SSD 70889211 – Marsden Park Data Centre

The submitted documentations related to the Environmental Impact Statement have been reviewed by our officers and we object to the proposal as outlined in the summary of issues in Attachment A. We will provide more detailed comments and elaborate on these issues in a separate follow up addendum submission to you by 6 January 2025.

Blacktown City Council's submission to SSD-70889211- Marsden Park Data Centre (SSD-70889211) (Blacktown) – at 105 Hollinsworth Road, Marsden Park

CLIENT: **CDC DATA CENTRES**  
PROJECT: **MARSDEN PARK DATA CENTRE CAMPUS**  
105-113 Hollinsworth Road  
Marsden Park, NSW 2765  
DRAWING: **SITE SECTIONS 1**

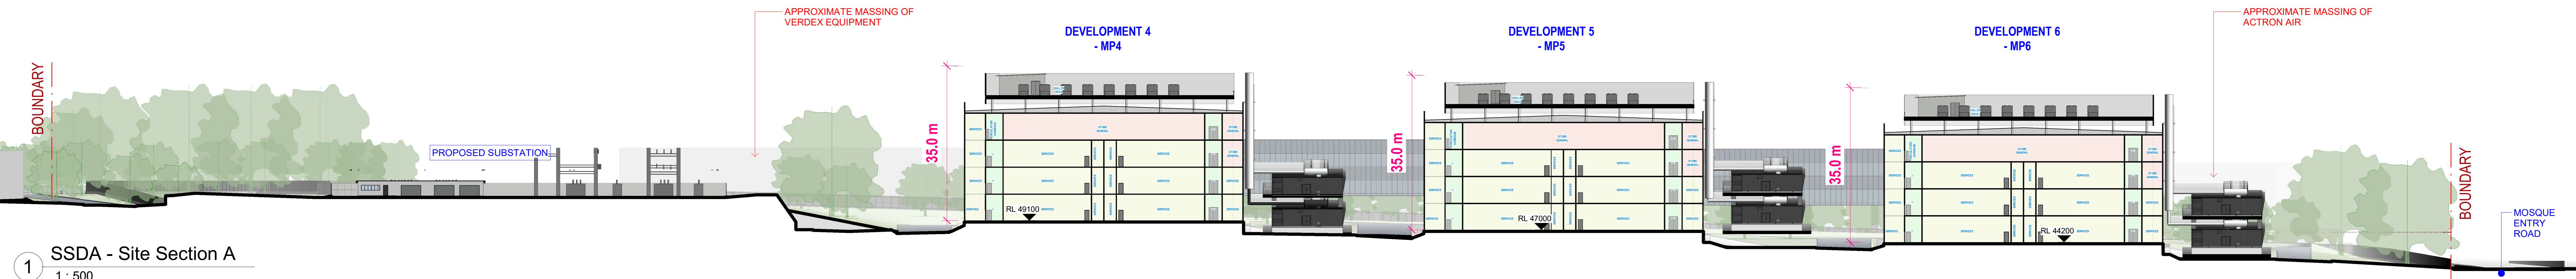
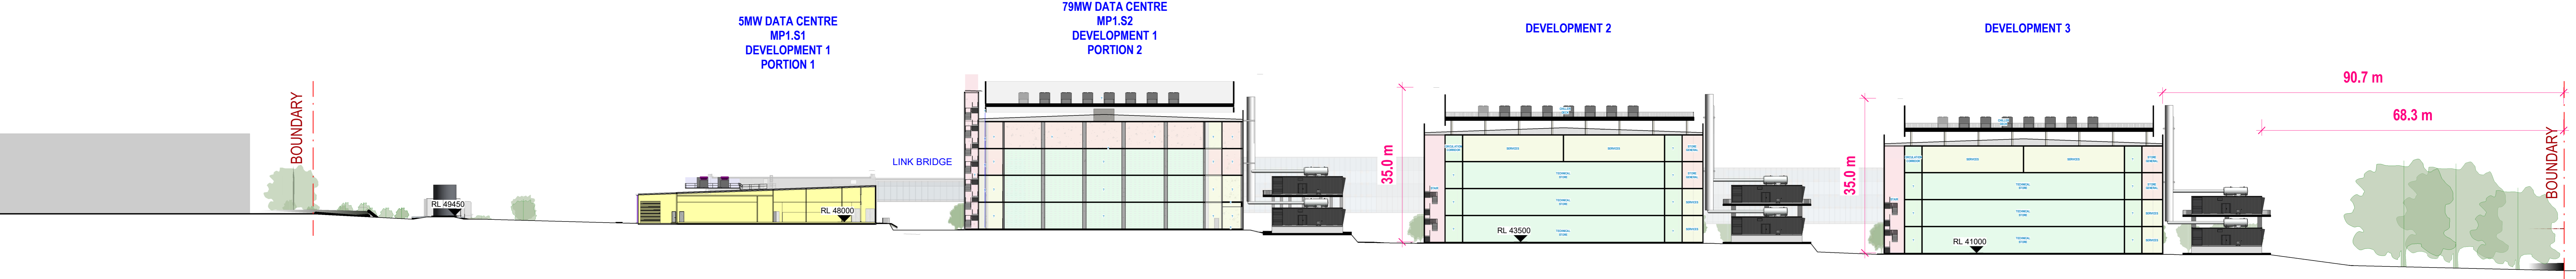
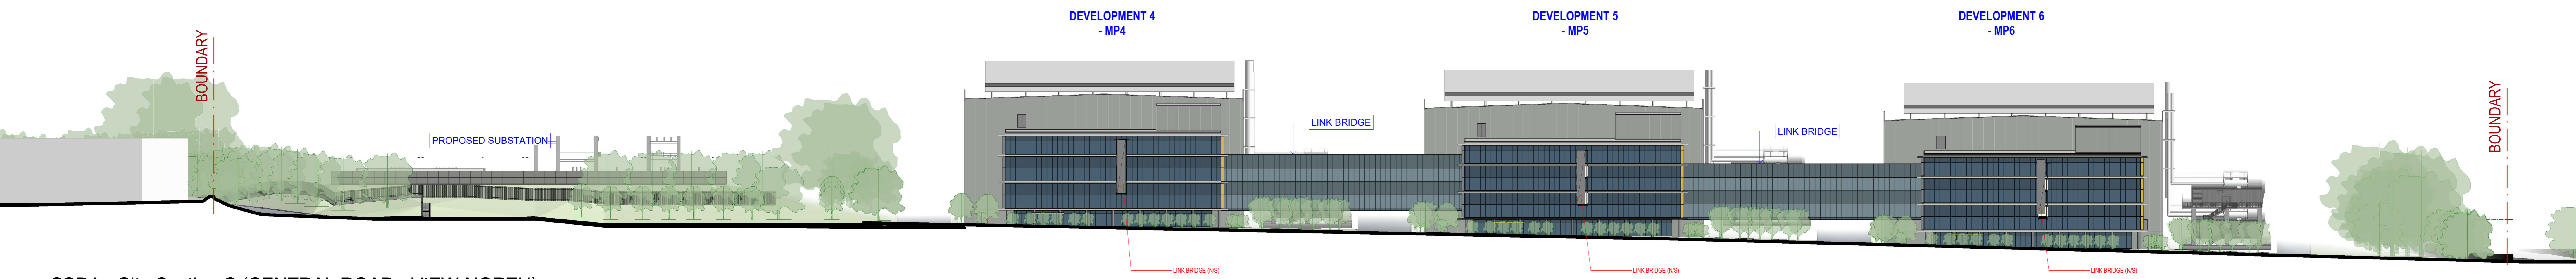
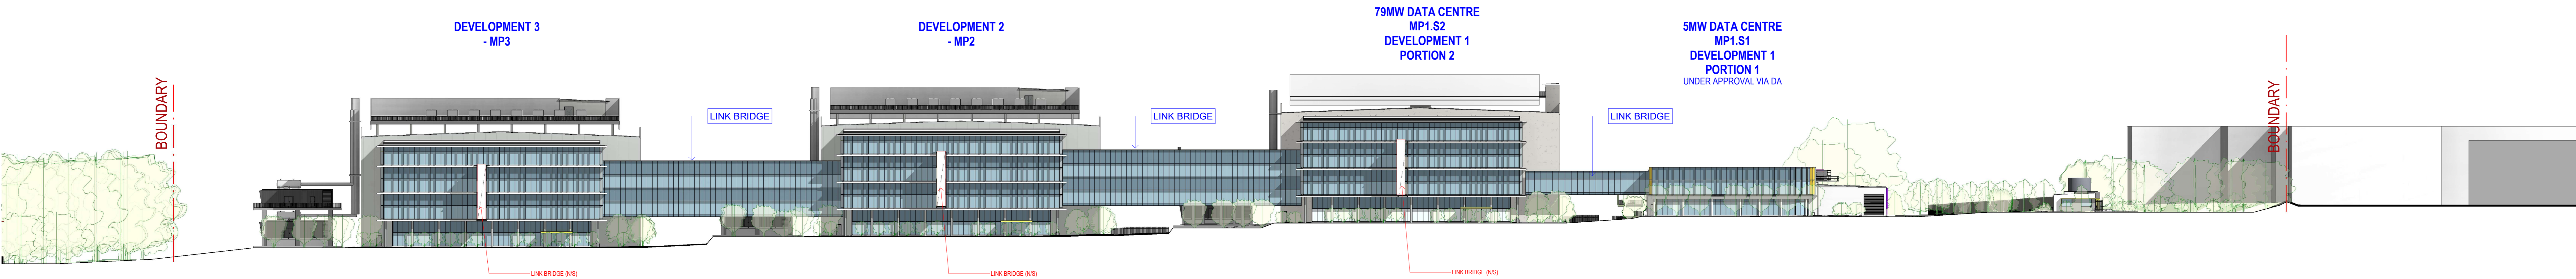
2. Provide cross sectional diagrams to illustrate the height of retaining walls, batters and offset of RW from adjoining neighbour's property boundaries.

1. Consistency of cut and fill and vegetation management as approved under DA-24-00452 (5 MW data centre) and DA-24-00386 (bulk earthworks).
2. Extent of retaining walls specifically along the northern boundary of the site.
3. Provision of landscaping buffers specifically along the retaining walls, including additional planting around the site as a genuine attempt for landscape screening independent from other surrounding structures and properties.
4. Provision of sufficient car parking spaces for the data centre use, and provision of additional car parking for future change of use feasibility.
5. Potential bulk and scale impacts to the surrounding properties and public domain arising from the proposed acoustic treatments and building height, materials and finishes.
